**From:** Marjorie Ferguson <marjorie.ferguson@canadabay.nsw.gov.au>  
**Sent:** Wednesday, 25 June 2014 4:43 PM  
**To:** Mark Brown  
**Cc:** Fiona Gibson  
**Subject:** Mod Request for 44-46 Walker Street Rhodes (Mod 4 MP 10\_0105 75W)

Area Calculations -
GFA

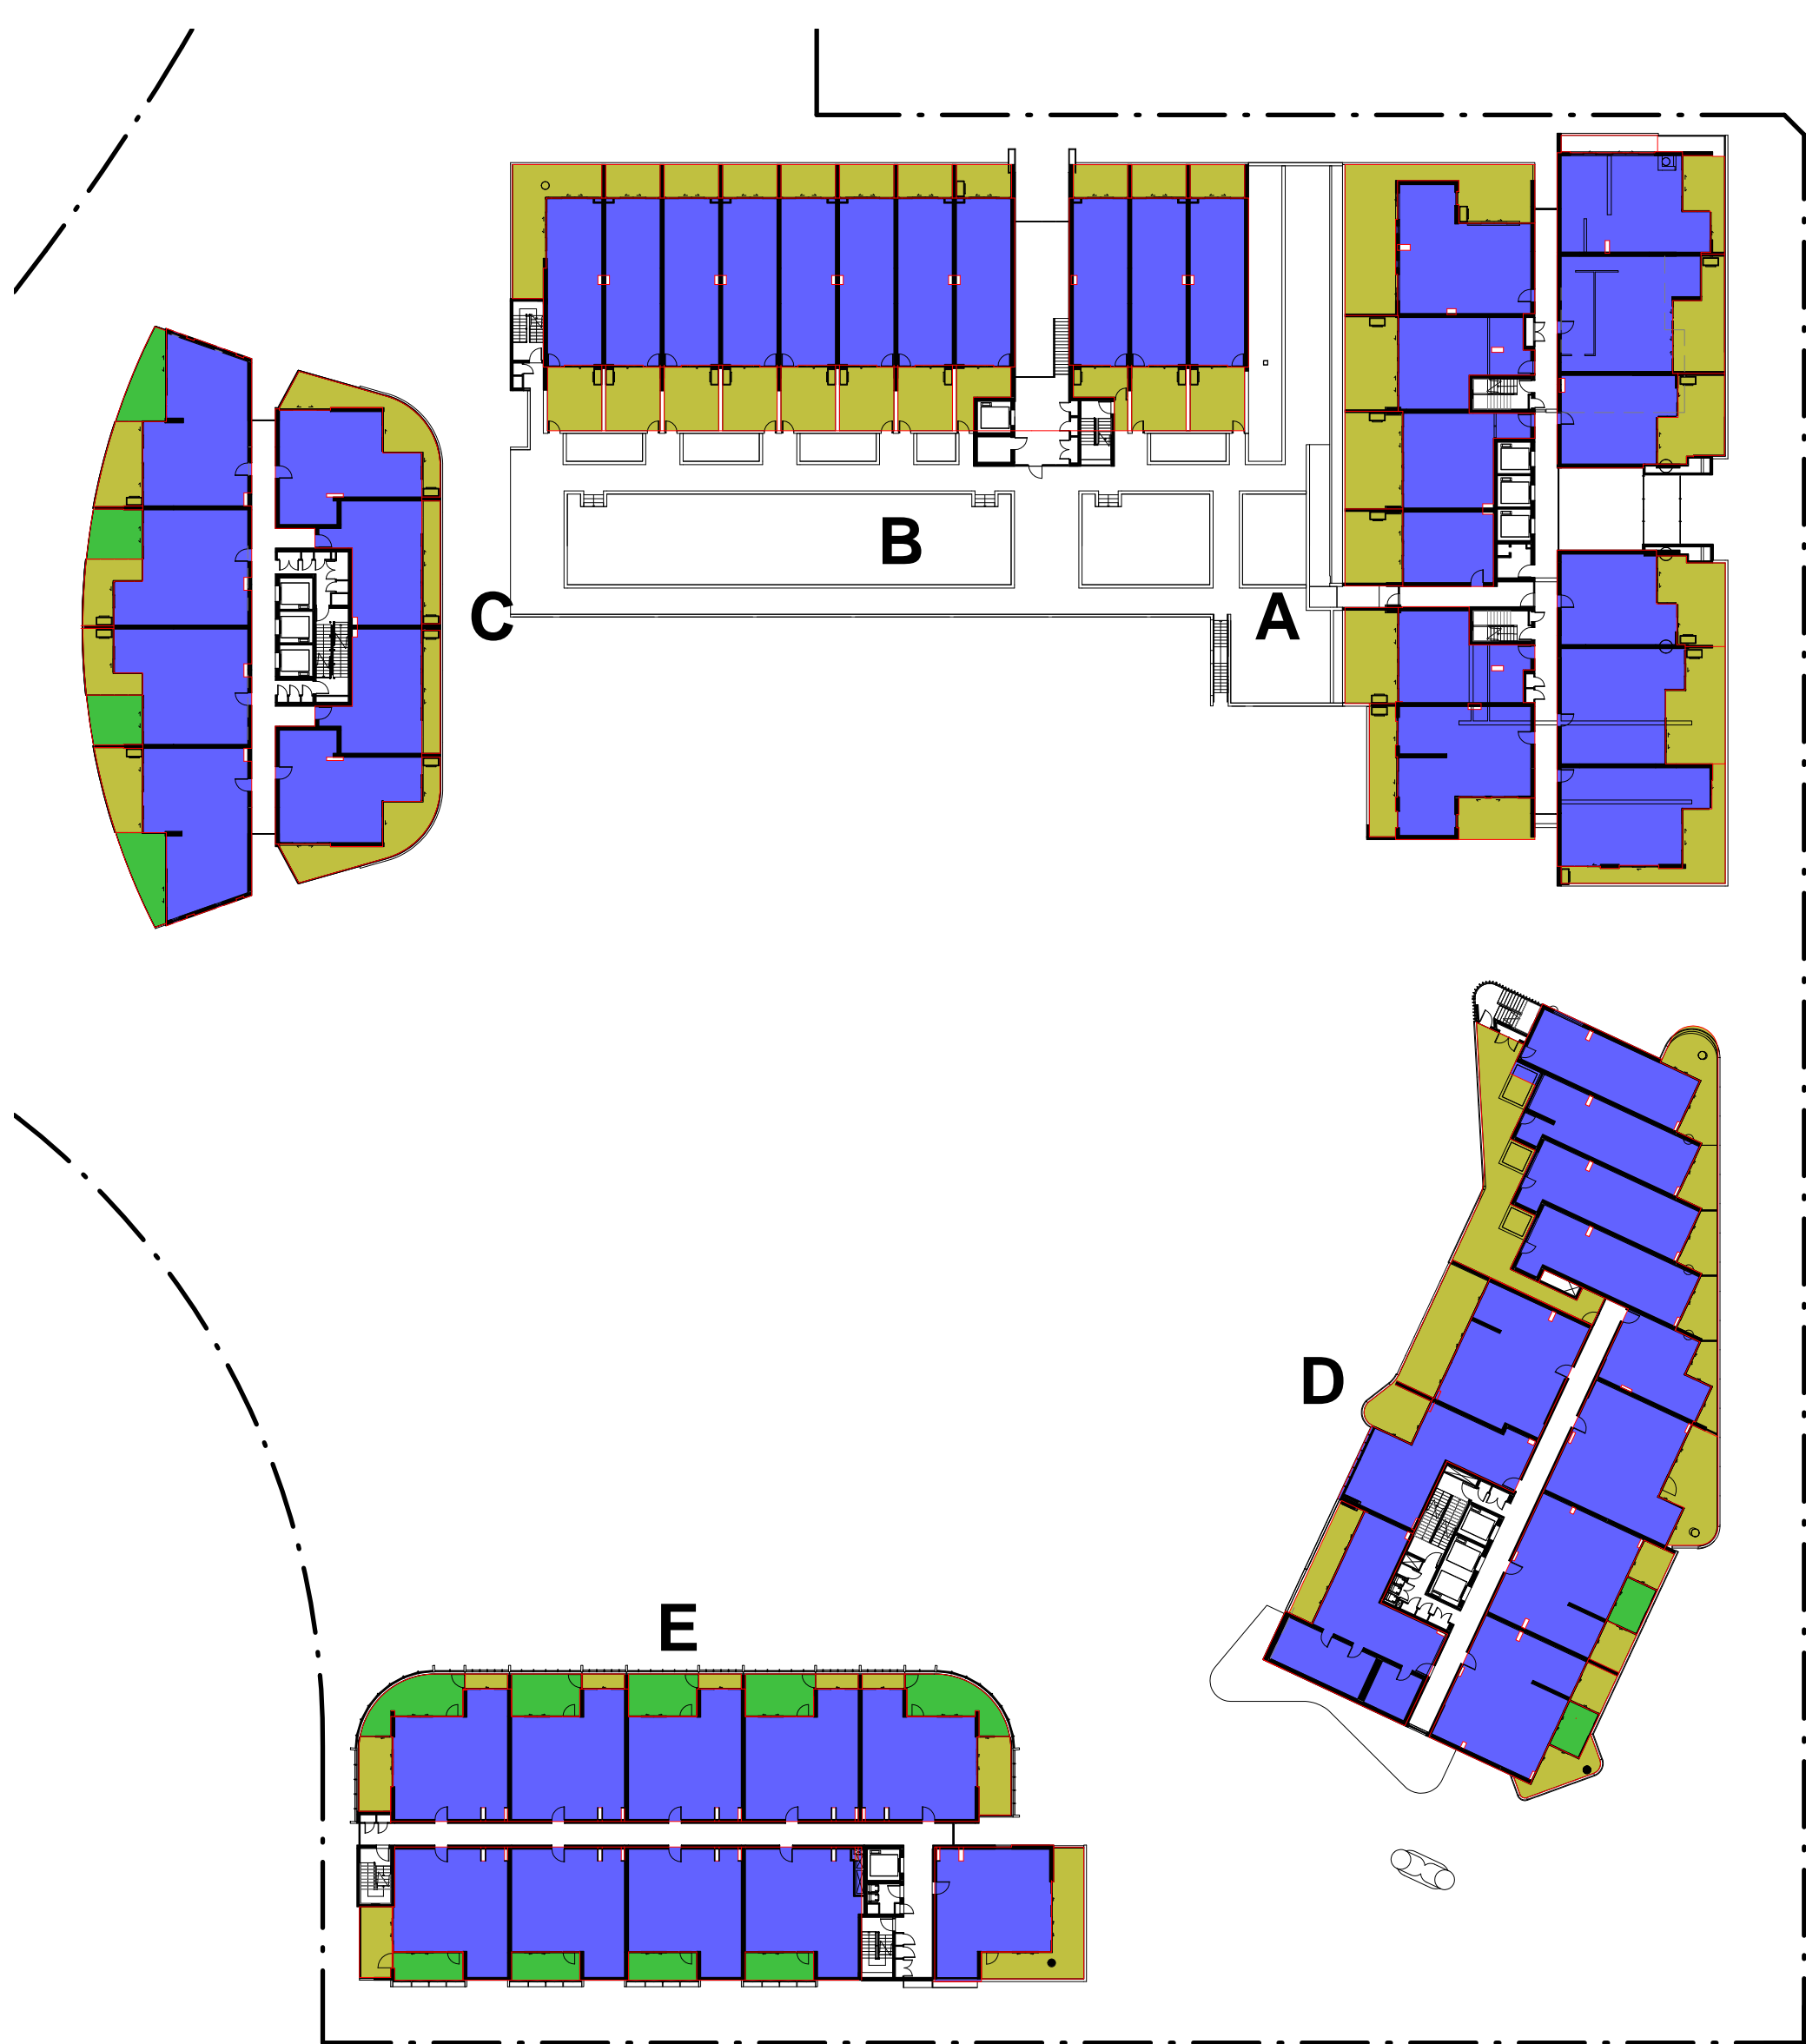
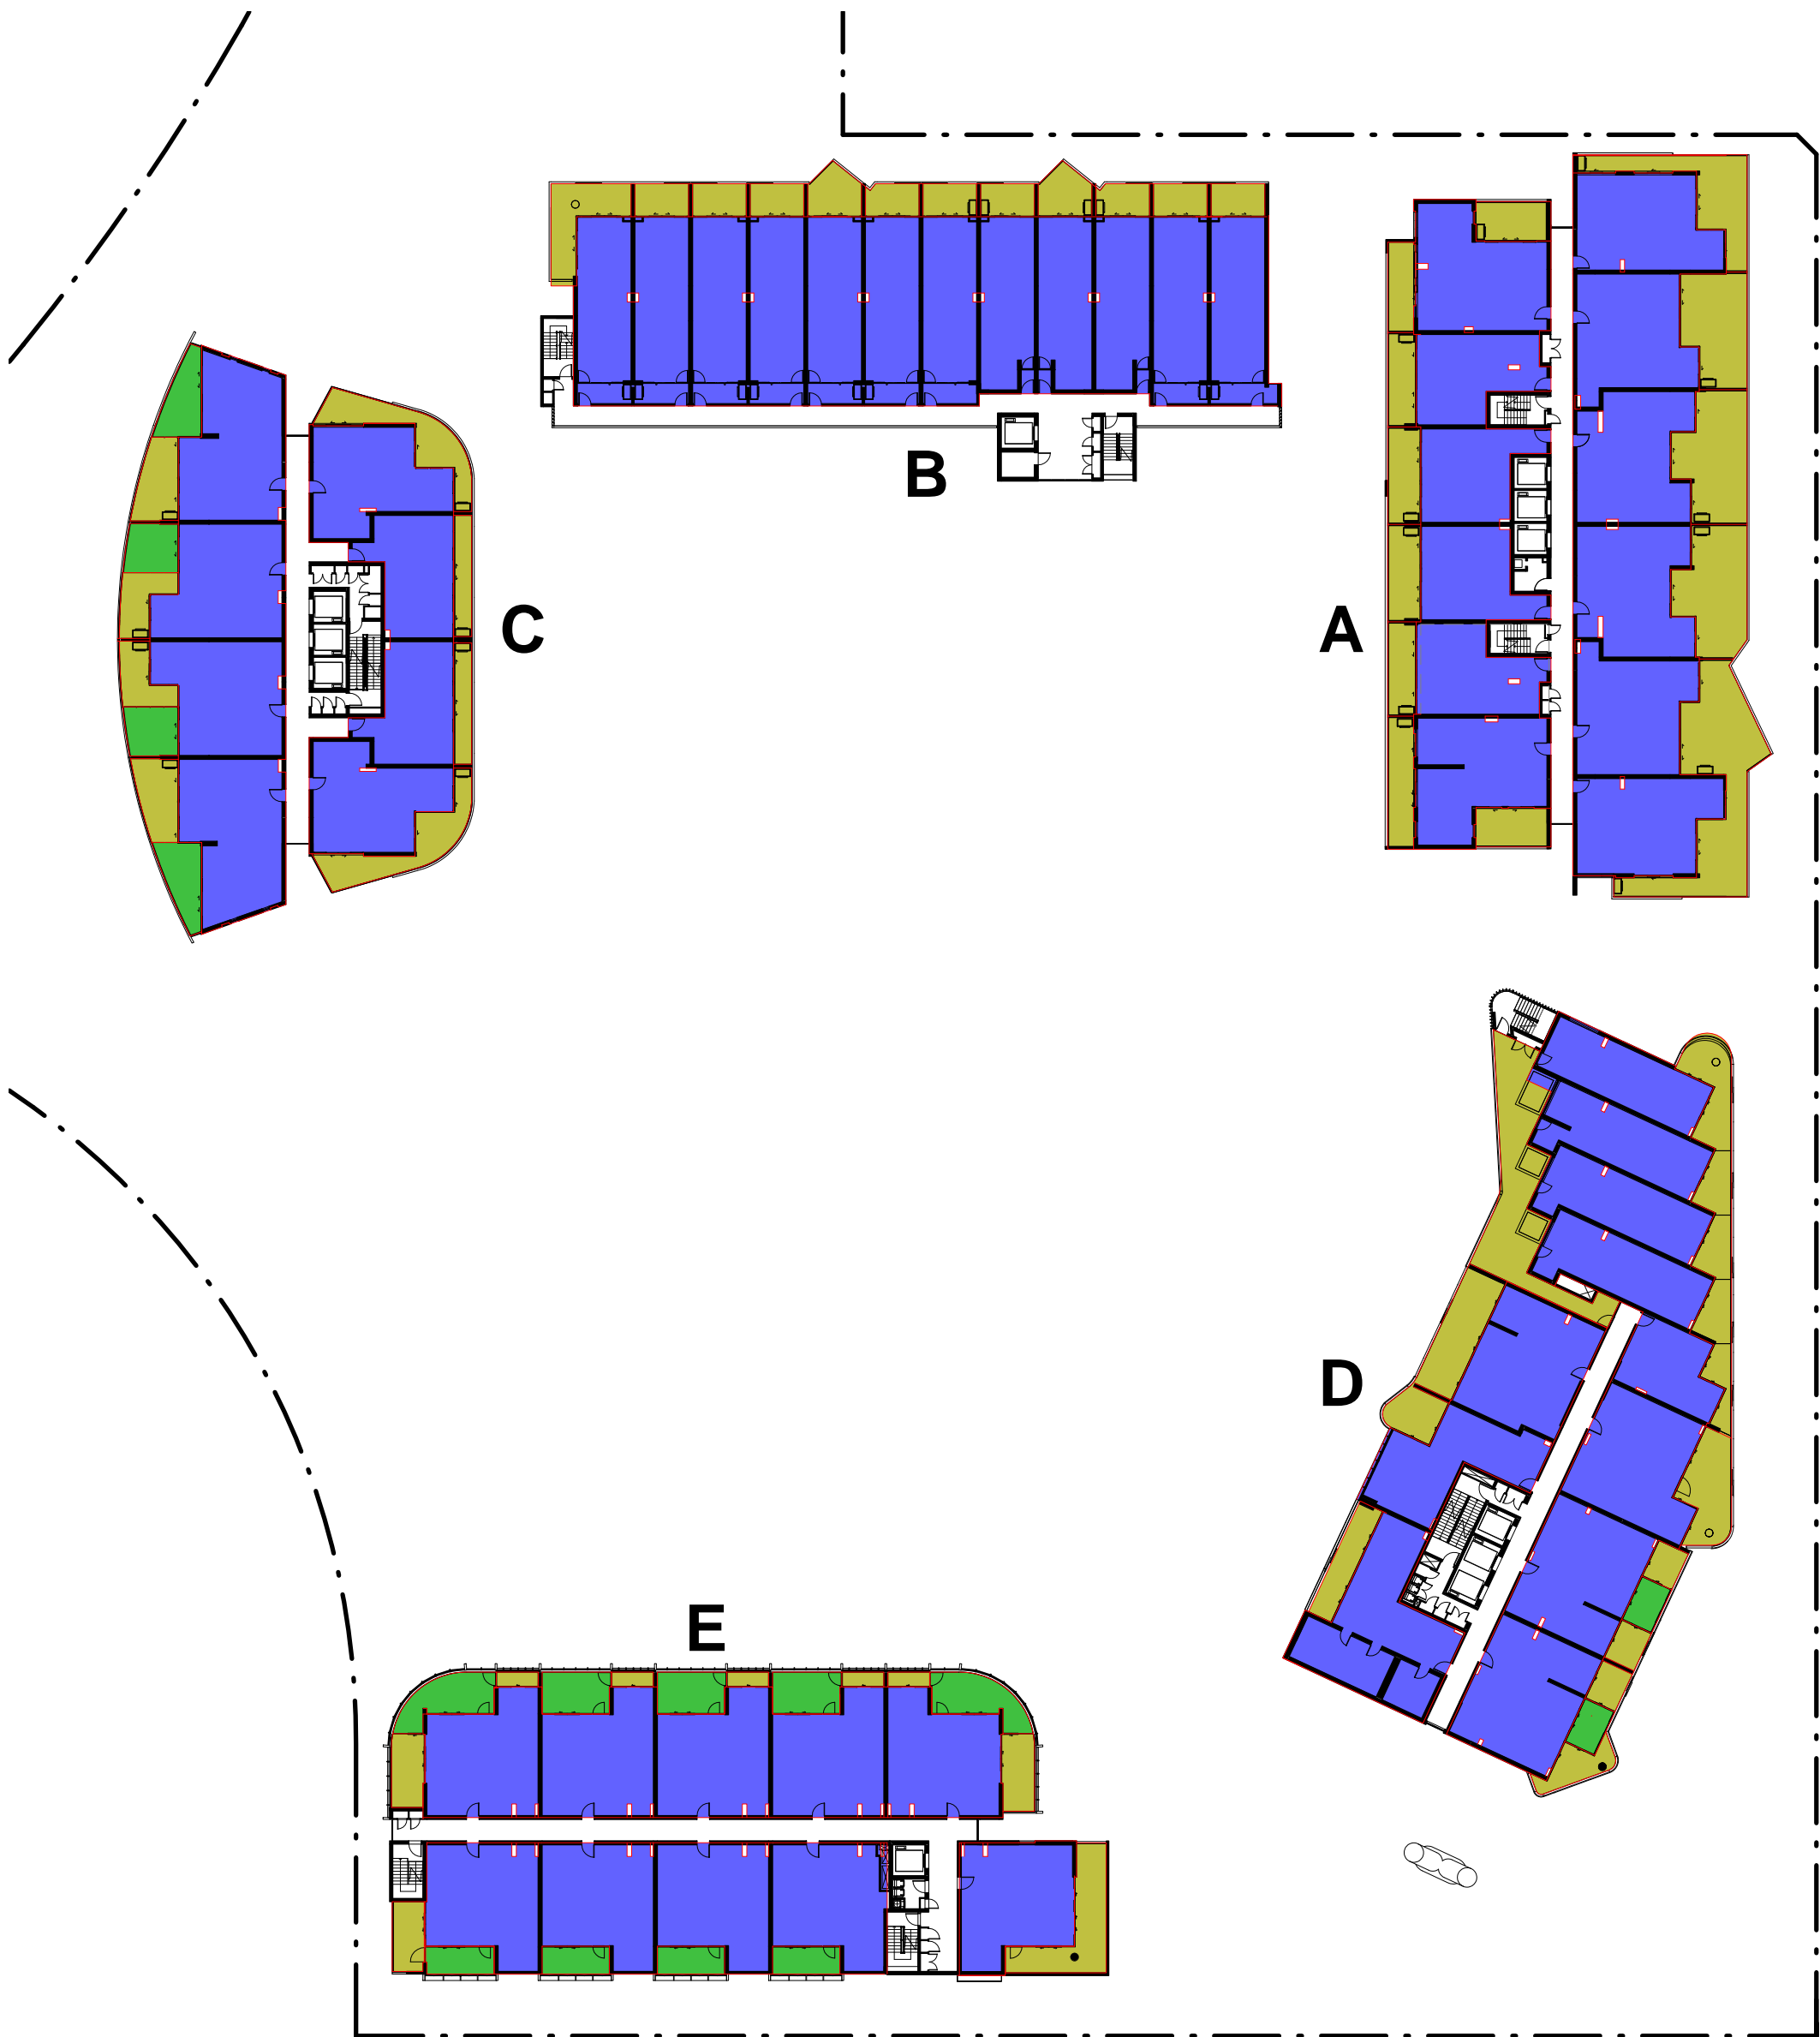
We do have a concern about the common rooms being converted to retail for the following reasons:

- Common rooms are important for residents to hold meetings, small gatherings etc., not all of which can take place in the open space areas as suggested by the applicant. This building will accommodate many residents and common areas are important spaces particularly rooms that face onto open space. It is not always reasonable to expect residents to use the proposed community centre.
- The new residents of the Bridgehill Development on Shoreline Drive are trying to reverse a decision made (by Council) to convert common areas to retail spaces. The residents are arguing that they bought units off the plan on the assumption that there were common areas available. I am not sure if the units of the subject site have been sold (off the plan) but it is a situation that ought to be considered.
